From: Bruce Taunton <Bruce.Taunton@arun.gov.uk>
Sent: 02 March 2020 17:01
To: Planning.Responses <Planning.Responses@arun.gov.uk>
Subject: RE: Planning Consultation on: BR/351/19/PL

NOTIFICATION FROM ARUN DISTRICT COUNCIL
Town & Country Planning Act 1990 (as amended)
Town and Country Planning (Development Management Procedure) (England) Order 2015
Planning Permission
APPLICATION NO: BR/351/19/PL

Site Address: 65 Upper Bognor Road (Charlotte House 71 & 71A Upper Bognor Road, 67 & 69 Upper Bognor Road Bognor Regis PO21 1HR

Description of Works: Erection of 2 No. live-work units; change of use of existing student accommodation including internal alterations to form 2 No. dwellings, 2 No. new windows, new staircase & replacement of roof on outbuilding; reconfiguration of existing dwellings, replace existing timbers & roof joists on first floor; change of use from medical centre/offices to 2 No. flats & workshop. creation of new private gardens, separation of this part of the site from the wider University campus, creation of a shared landscaped courtyard, creation of areas for parking & storage for bins & cycles. This application affects the character & appearance of the Upper Bogno

University of Chichester  
Upper Bognor Road Residential Redevelopment  
Drawing  
67-69 Upper Bognor Road  
Ground Floor Proposed  
Scale @ A3  
1:50  
Drawing no.  
**5542-101-D2**

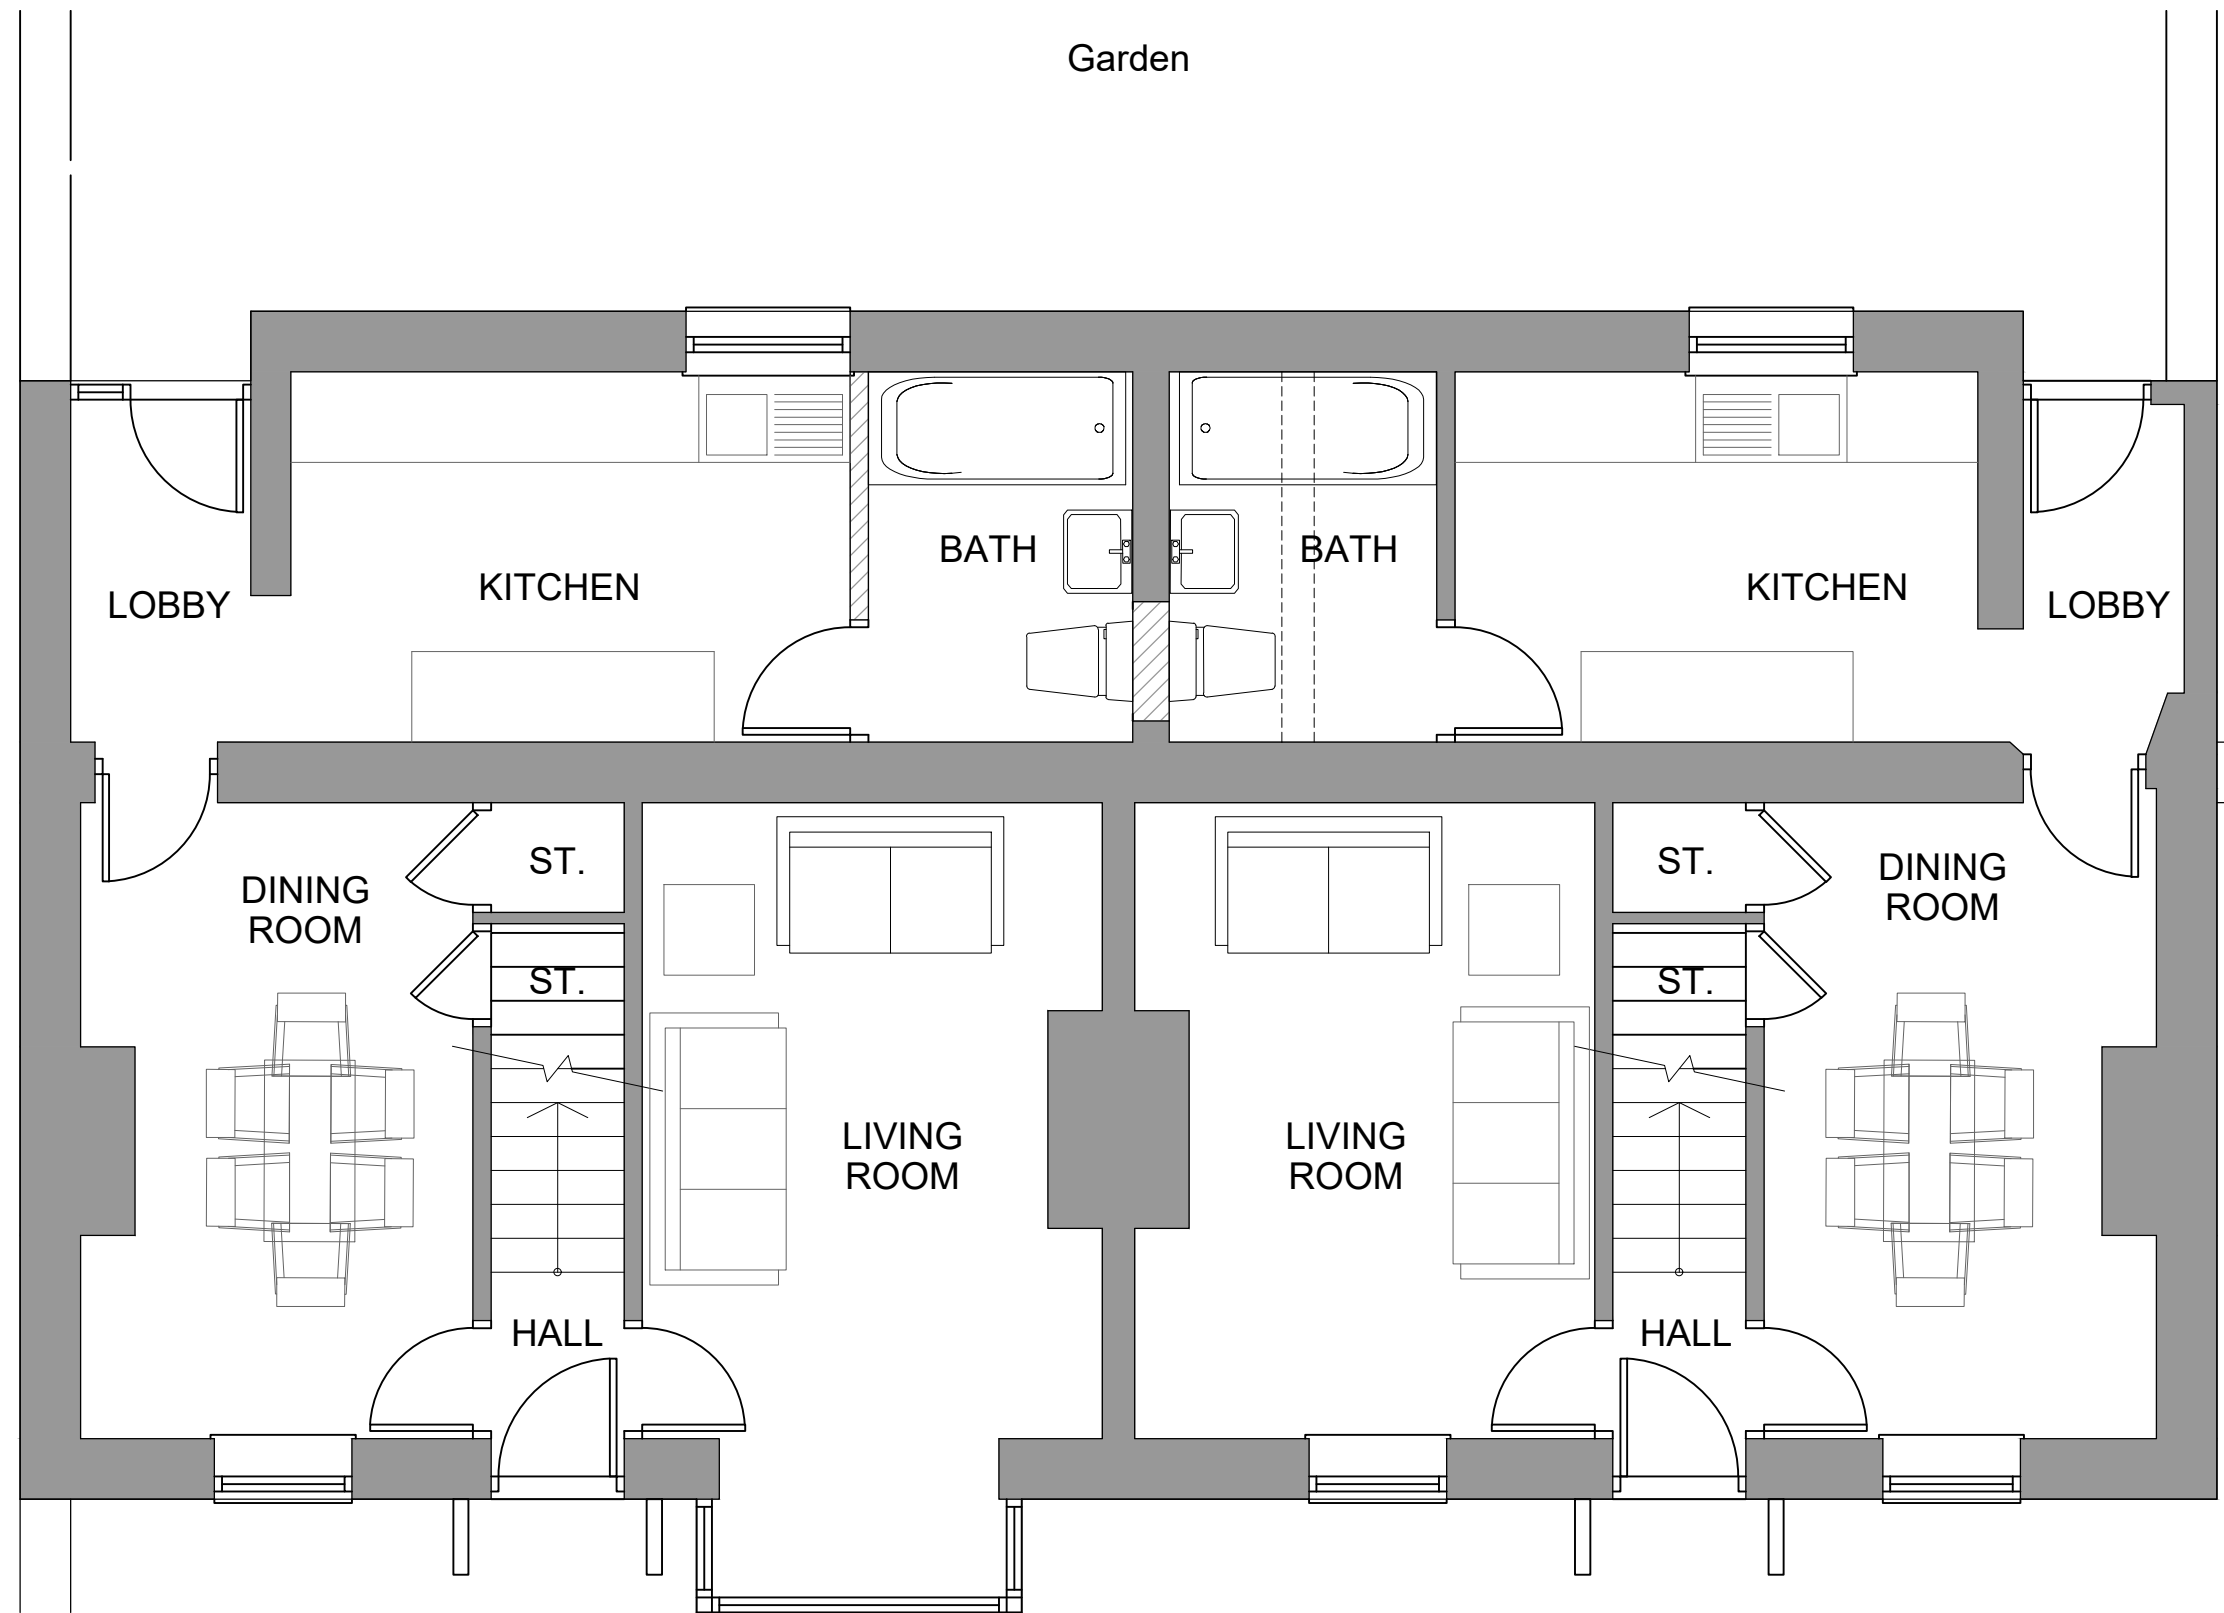
Strengthening proposals to the roof and floors to be fully justified by design and in accordance with the Building Regulations. Although the solid floor was mentioned how is this to be upgraded to meet the current thermal regulations without affecting ceiling heights, access etc.
